Reference: 21.185r02v02

9 May 2022

Re: St Aloysius – Rozelle Campus
Response to Request for Information

Figure 12: Pick Up and Drop Off Location

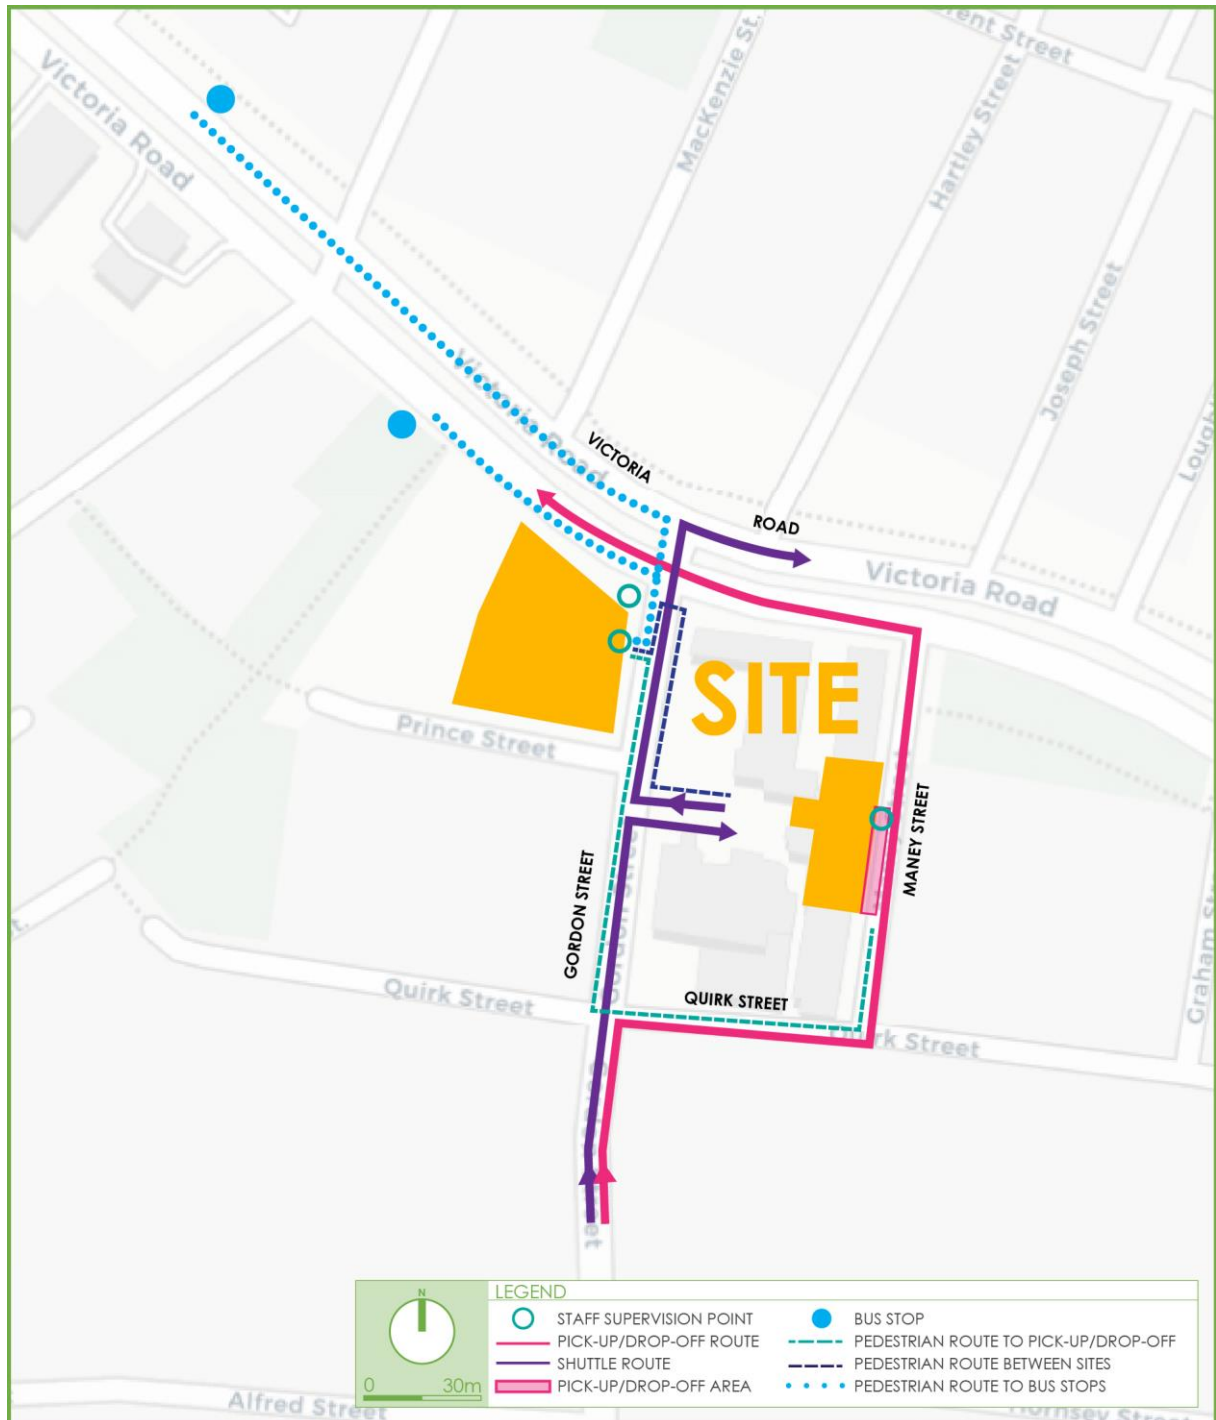
- *"Objection to the proposed pickup/drop off area provided in Maney Street, as this would result in the loss of existing 2P Resident Parking Scheme areas."*
- *"Additionally, this arrangement would create the possibility of vehicles queuing in Quirk Street and blocking off the street. The same queuing issue also applies in Gordon Street, which is a Regional Road carrying about 3,000 vehicles per day."*

- *"Drop Off and Pick Up (DOPU) - A DOPU zone is proposed on the western side of Maney Street. In this regard, please provide a scaled plan to indicate the accurate location and length of the proposed DOPU zone."*

The additional parking surveys conducted in the streets surrounding the proposed development on 10 February 2022 show that there is sufficient capacity to accommodate the three (3) proposed drop off and pick up spaces. Refer to the updated TAIA for the detailed survey analysis. The revised location for the drop-off and pick-up spaces are along the site frontage to Maney Street, away from the intersection of Quirk Street.

TRAFFIX Response:

As part of the updated TAIA, a scale plan has been prepared showing the location of the proposed drop-off and pick-up area. This is provided within Section 11.3 of the updated TAIA.

Car Park Mark Up

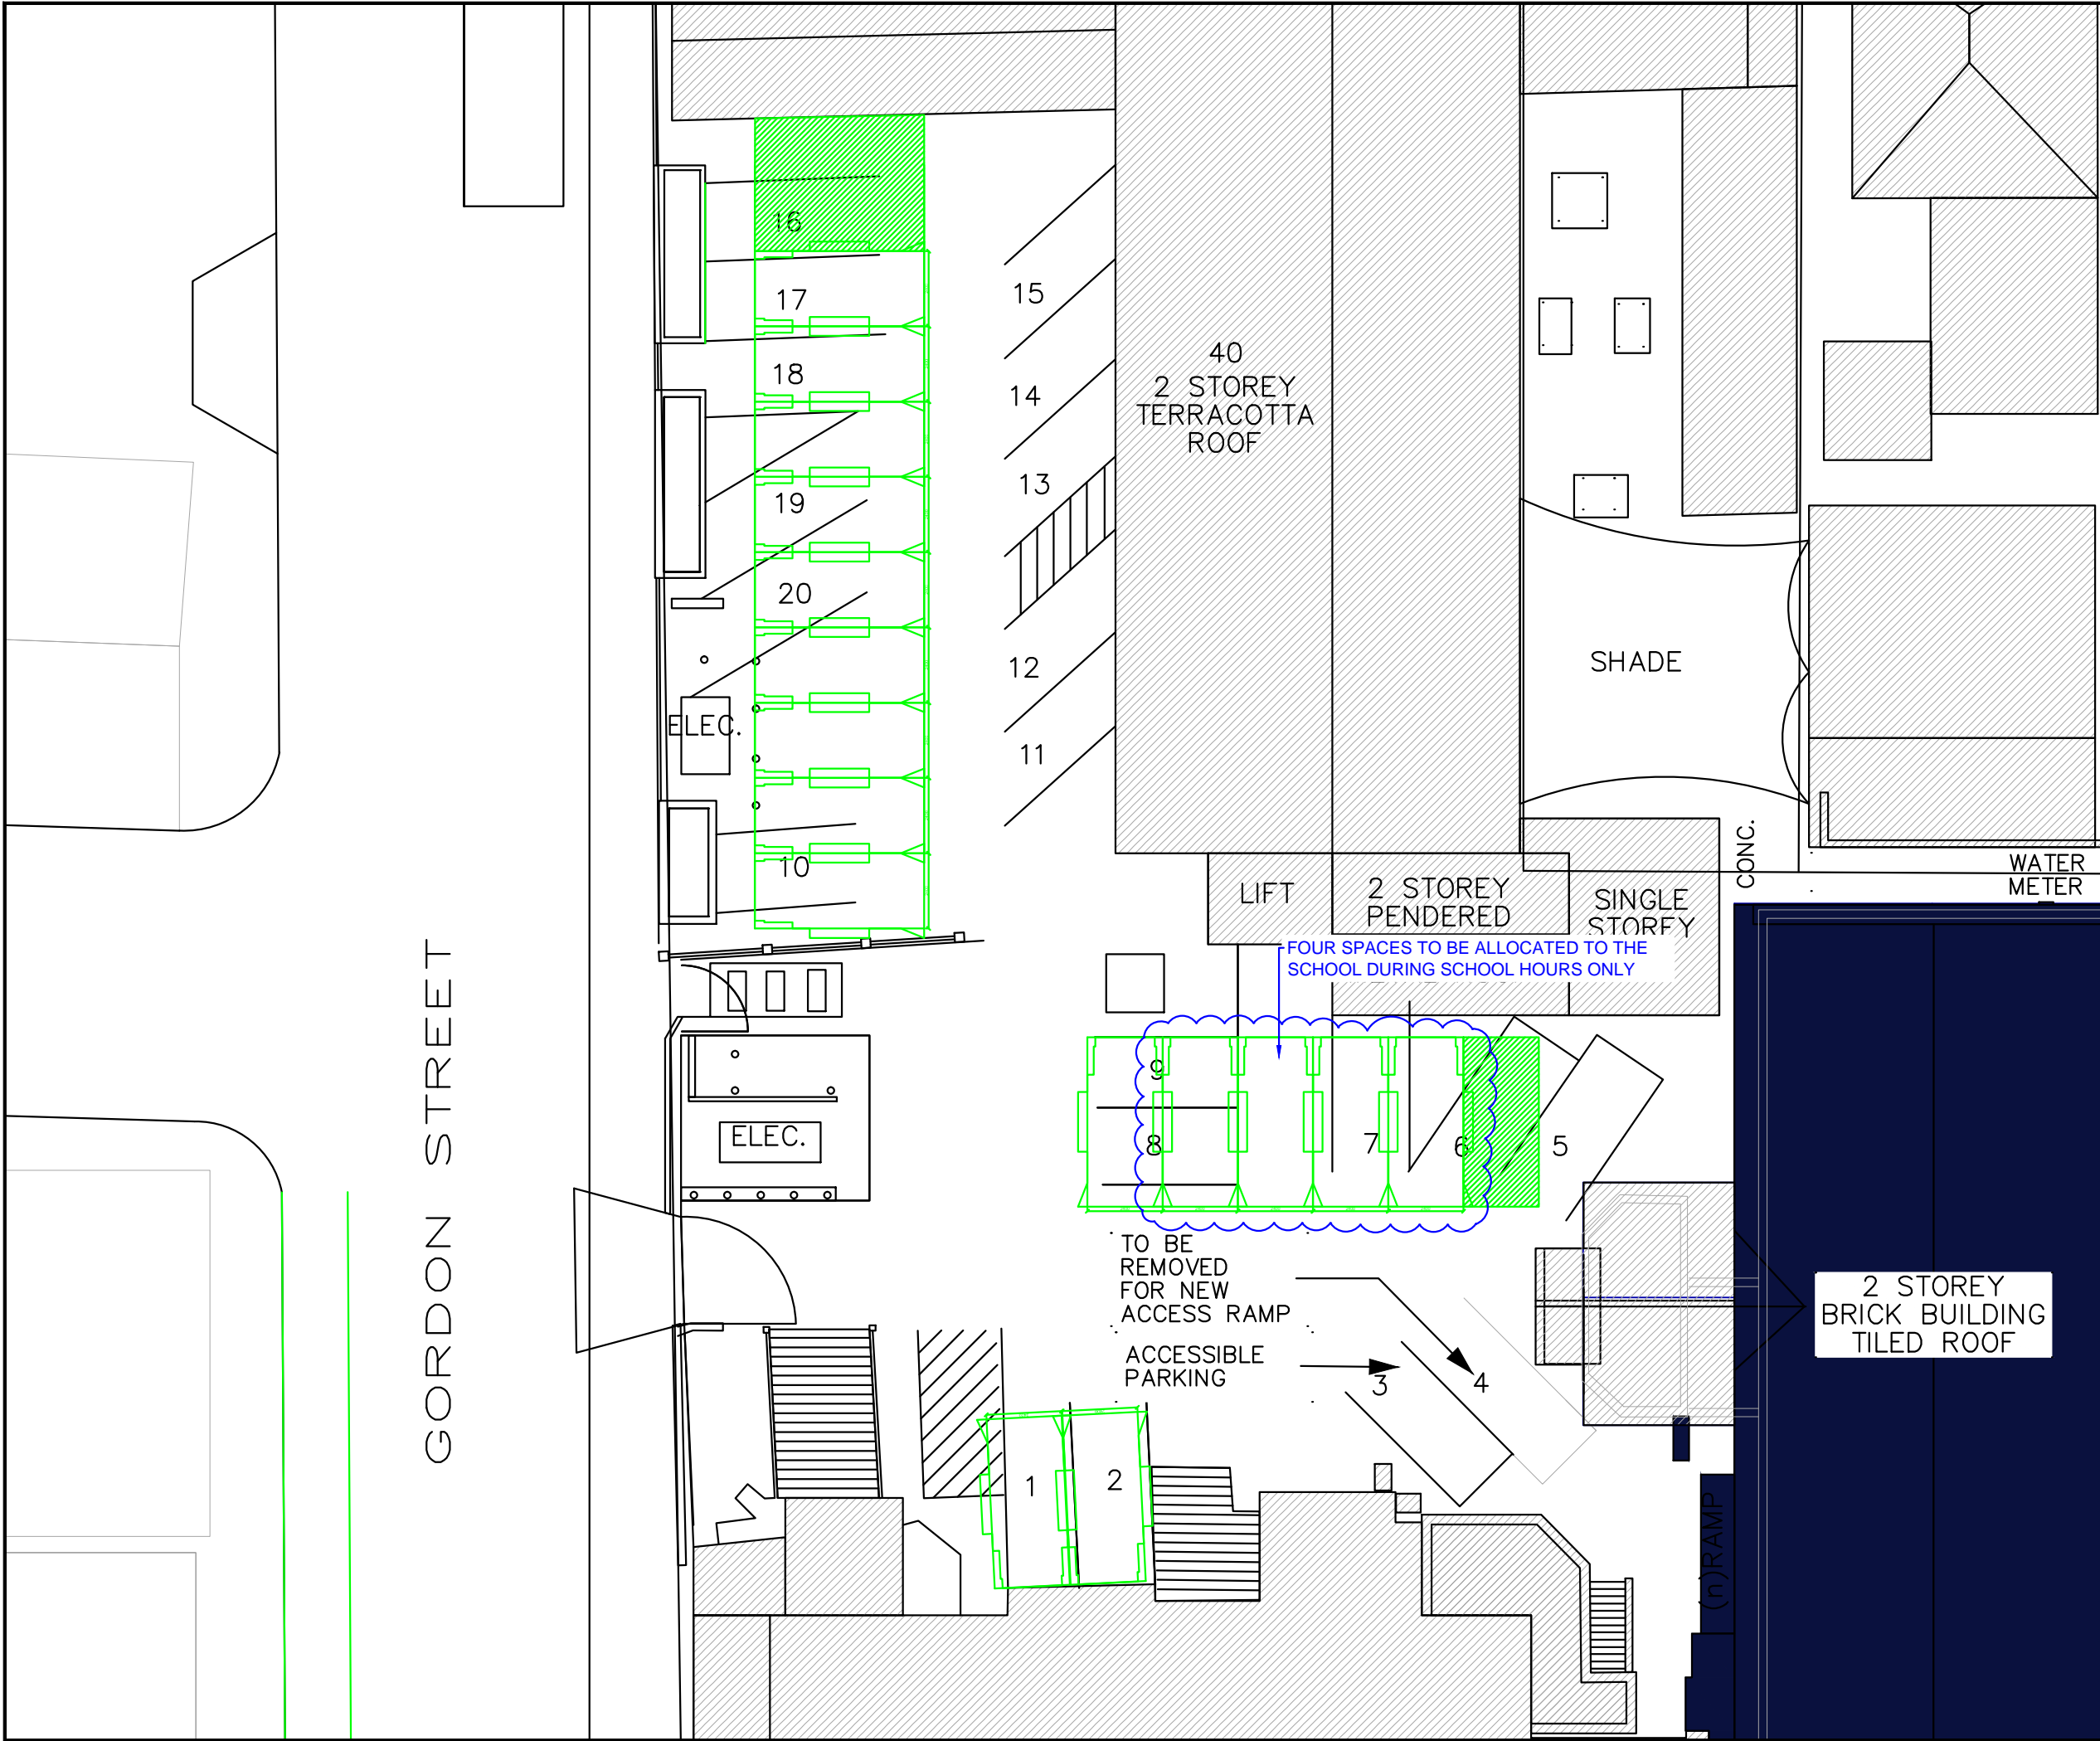
- *“The EIS does not include any details of the use of the ground floor of 2A-2B Gordon Street, nor does it indicate how many parking spaces would be required to cater for the other uses within the site including the church use. The TAIA also does not assess how the overall car parking area would operate with the concurrent uses on the site and whether the available car parking spaces are sufficient to cater for all of the uses within the site. Consequently, the Department requests that you submit a parking layout plan and mark the nominated parking spaces for the proposed development as well as all of the other uses within the site.”*

- *"Car parking spaces - Insufficient information has been provided to clarify the allocation of car parking spaces on the subject site. Appendix G states that the peak parking demands of other uses on the site will not coincide with the school use. However, according to the Operational Plan of Management, the other uses of the site operate during school hours. The TAIA should provide the details of allocated parking for each use on the site including the number of parking spots allocated for the use of the unit which is proposed to be used as the school in the future. In addition to clarifying the allocation, the TAIA should also assess the impacts of allocation of 4 spaces to the school, on the other concurrent uses within the site. This information was requested during EIS exhibition, but has not been provided."*

As detailed within the updated TAIA, the school will be leasing four (4) spaces from the existing on-site carpark at 2B Gordon Street, Rozelle. Section 7.1 of the TAIA has been revised to address the other uses on site and how the peak parking demands of these uses will not coincide with the school use. Additionally, the four (4) spaces will be signposted for school use only during school hours. Please refer to the plan of management and the updated TAIA which addresses this arrangement in further detail. Therefore, the proposed parking arrangement will accommodate all existing and proposed demands on-site.

The school has prepared a parking plan which provides an overview of the parking demands at different times during the week. This plan demonstrates the parking demands for the different uses on the site do not exceed the parking existing parking provision of 19 spaces. Therefore, the four spaces required by the school can be accommodated within the existing parking provision and the concurrent parking demands. Further details can be found in Section 7.1 and Appendix D of the TAIA
